RE: Carpenter Boundary Line Adjustment, BL-10-00030

Map Number 18-18-29051-0001 Parcel Number 562633

Map Number 18-18-29051-0002 Parcel Number 18682

TO: Jeff Watson, Community Development Services
FROM: Christina Wollman, Planner II *W*
DATE: August 5, 2010
SUBJECT: Carpenter BL-10-00030

CARPENTER SHORTPLAT # 03-19
 S44, S.29, T18N, R18E, WM

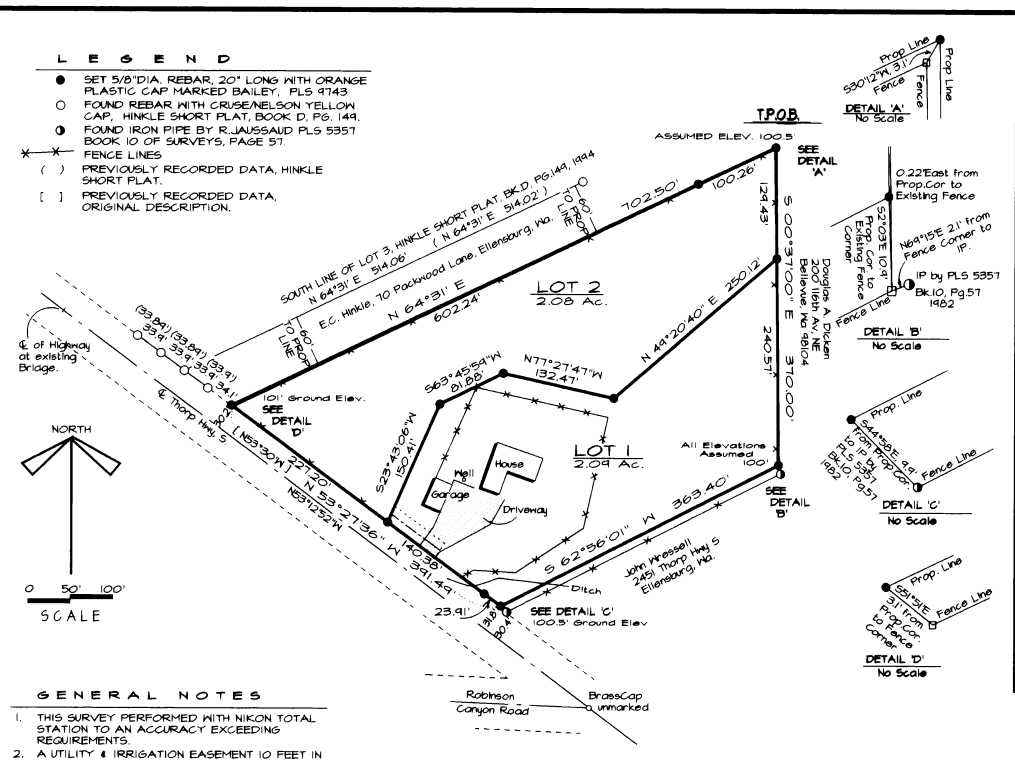
4. Wellhead protection areas KCC 17A.08.020; All non-community wells must be placed a minimum of 50 feet from property lines. OSDS Location KCC 13.04.080; Septic tanks must be located 5 feet from the property line, and disposal areas at least 10 feet from the property line. Verification of these setback requirements will need to be provided either on the recorded survey, or through a revised unified site plan with accurate dimensions.

- All future development must comply with the International Fire Code.
- Ensure that boundary line adjustments do not infringe upon existing structures, to include propane tanks, etc.

The well must be 50 feet from the proposed property line. The drawing doesn't show the distance that will be.
